# City of Albuquerque

February 19, 1990

RE: ENGINEER CERTIFICATION FOR AN ADDITION TO GERTRUDE ZACHARY  
OVERSMITH'S (J-14/D82) RECEIVED FEBRUARY 12, 1990

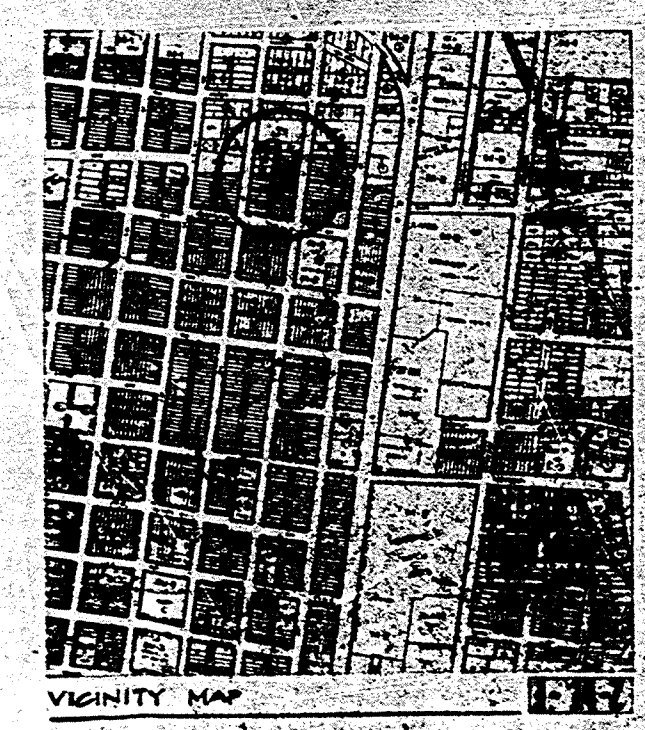
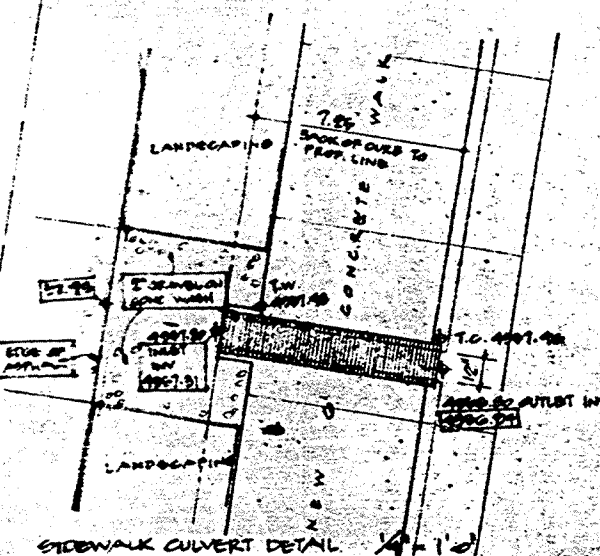
I am in receipt of your as-built certification for the referenced site. The Engineer's Certification statement portion is not legible, therefore, it is necessary for me to request that you date the statement and resubmit.
